CITY OF ALBUQUERQUE

April 7, 2023

**Re: 223 Sierra Apartment
223 Sierra Dr. SE
30-Day Temporary Certificate of Occupancy
Transportation Development Final Inspection**
Architect's Stamp dated 08-07-22 (K17-D094)
Certification dated 04-07-23

TRAFFIC
CIRCULATION
LAYOUT

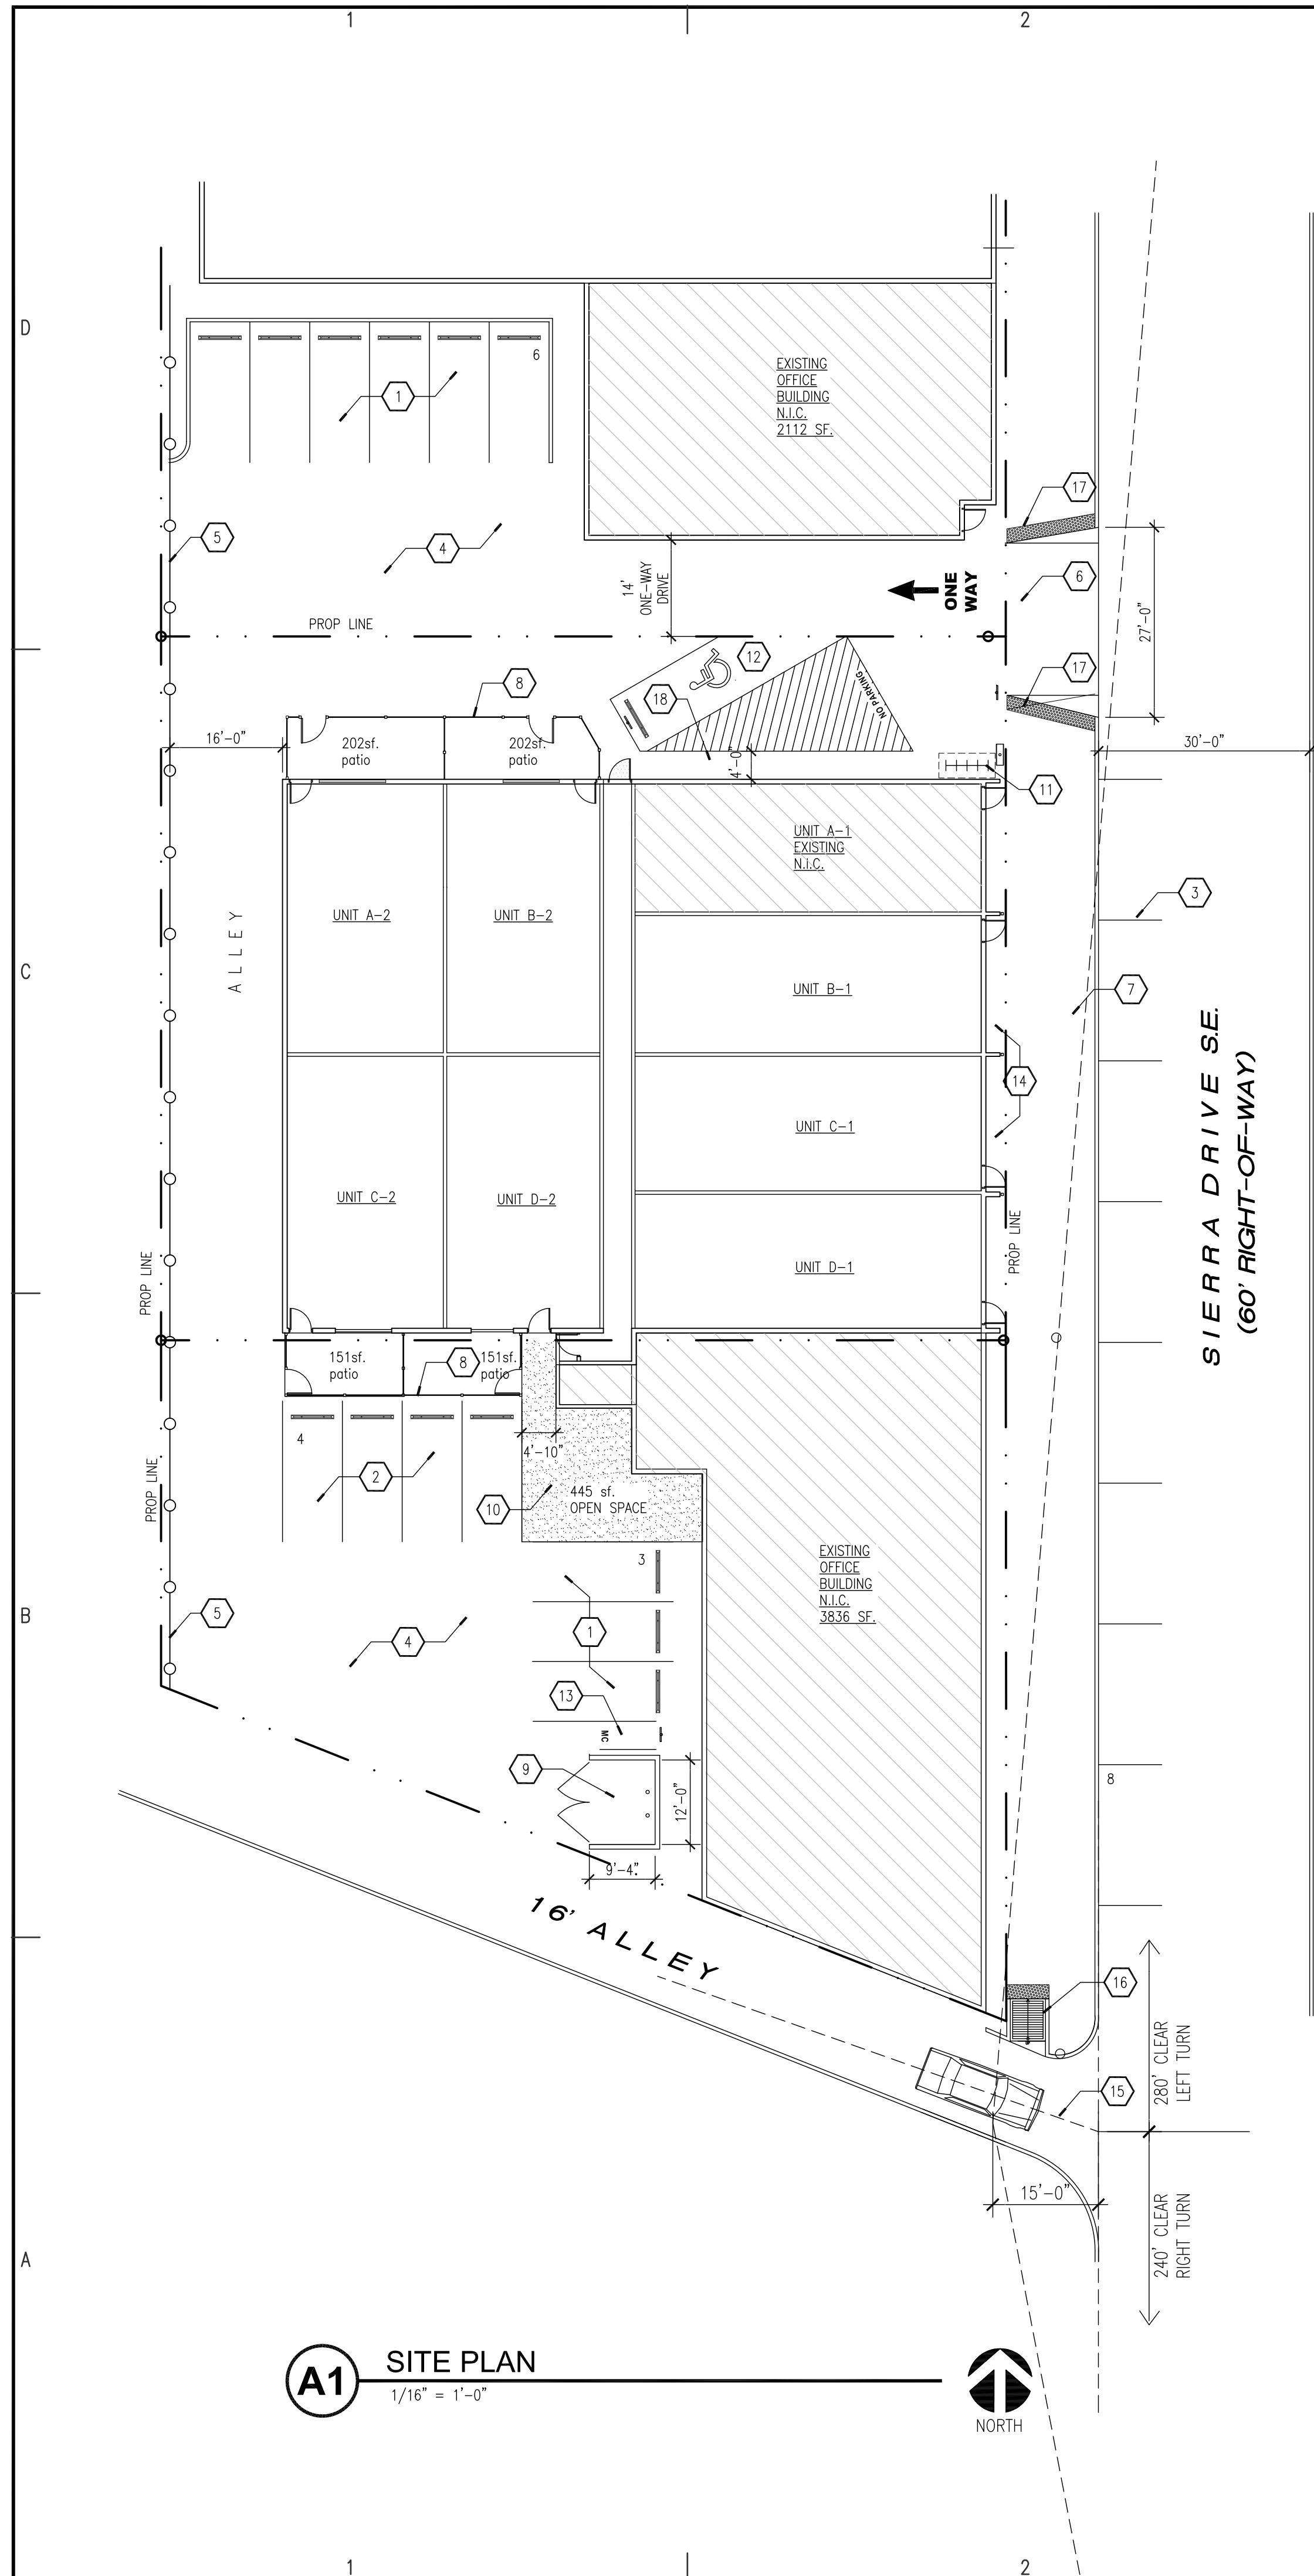
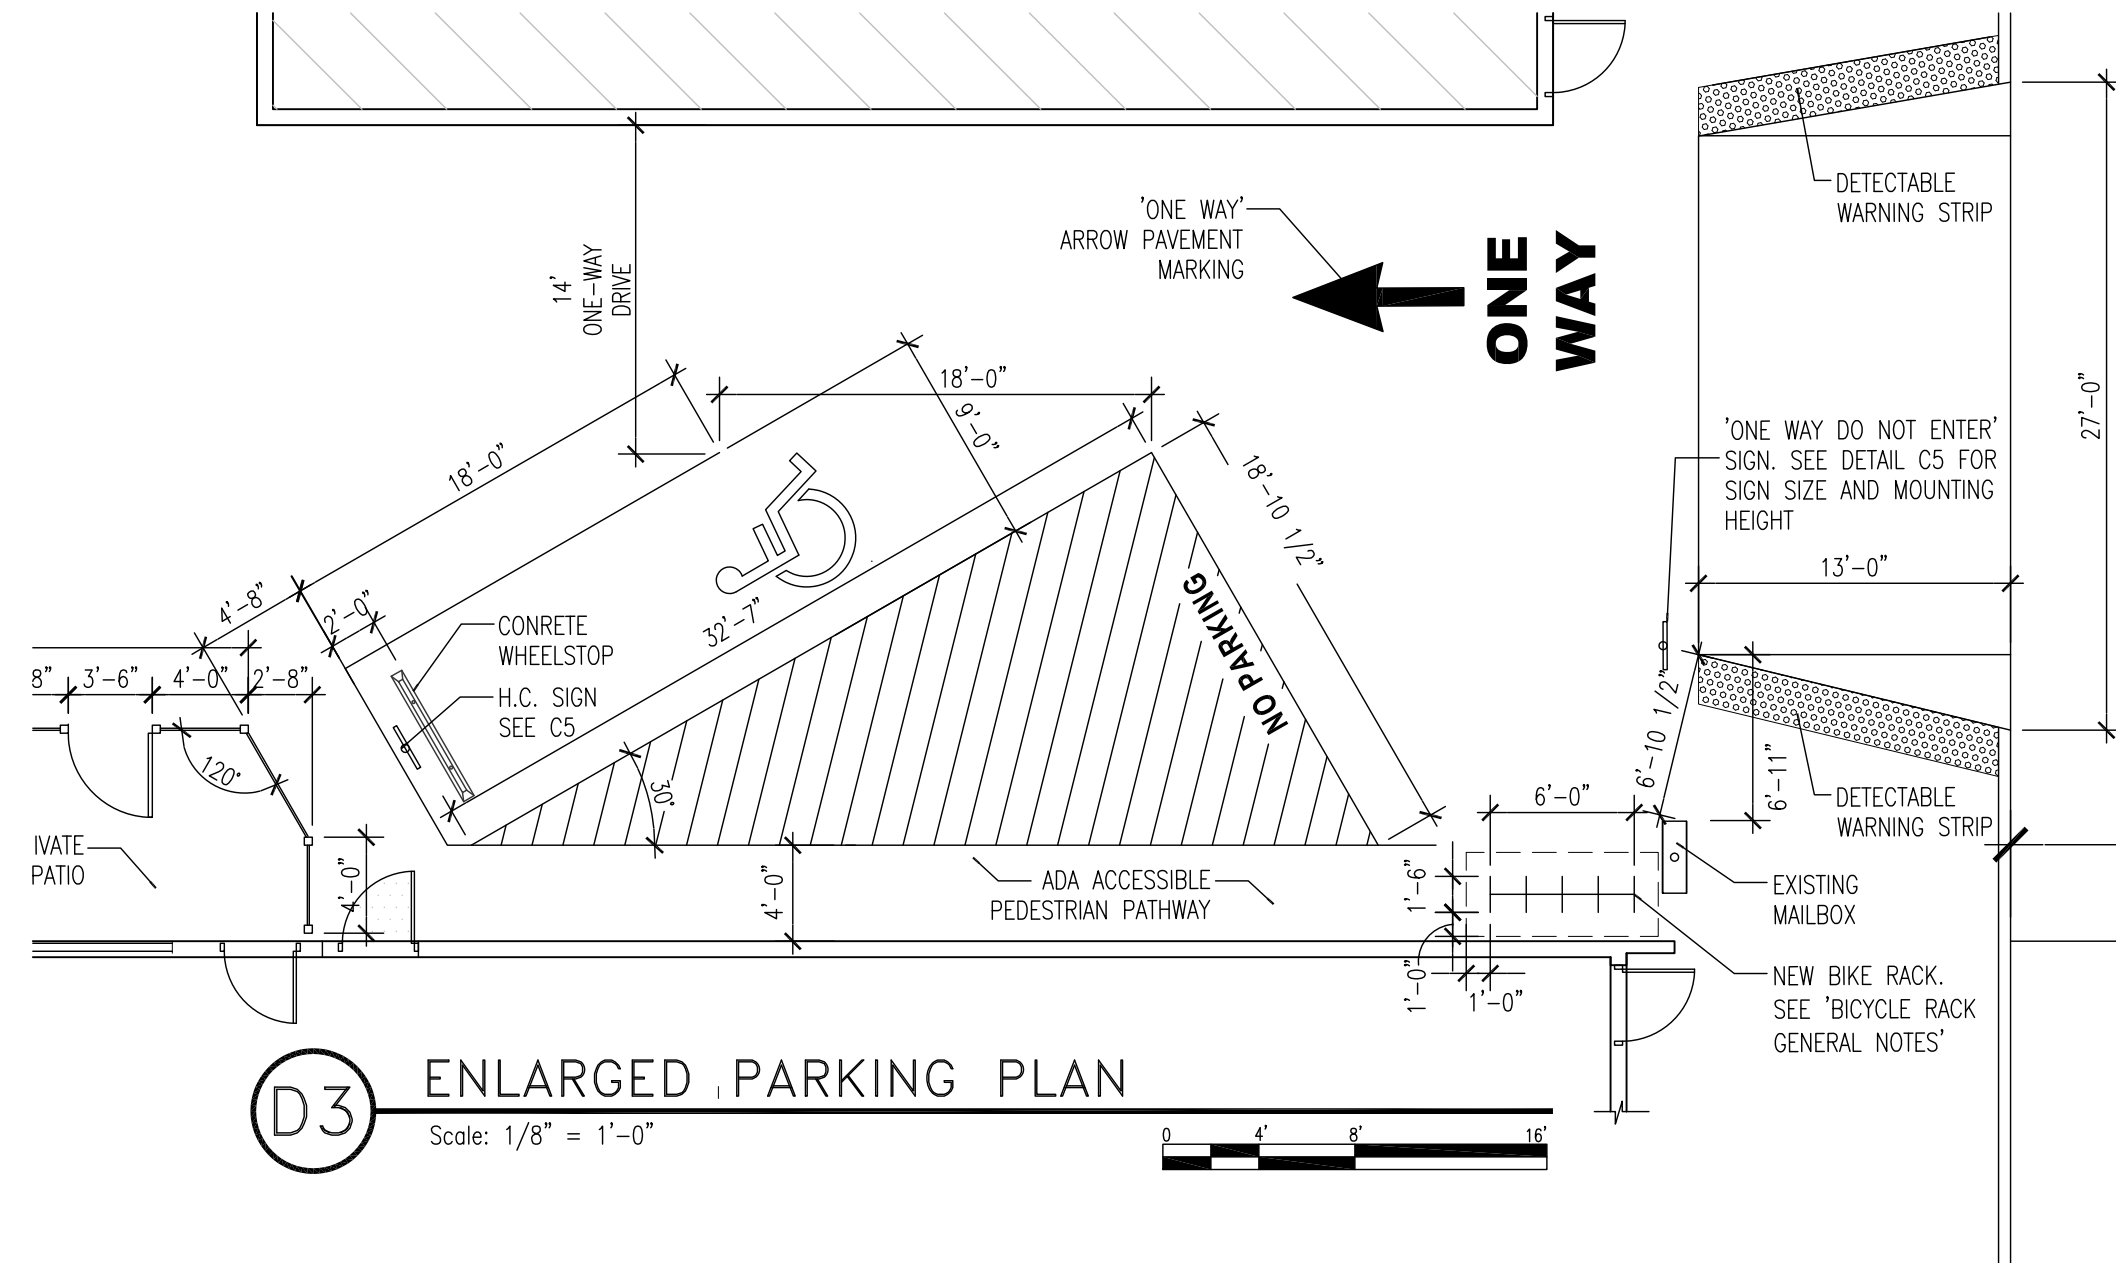
- The ADA access aisles shall have the words **"NO PARKING"** in capital letters, each of which shall be at least one foot high and at least two inches wide, placed at the rear of the parking space so as to be close to where an adjacent vehicle's rear tire would be placed. (66-1-4.1. B NMSA 1978)
- Keynote 16: per the approved plan, please build the ADA ramp at the corner of Sierra Dr. and the Public Alley.
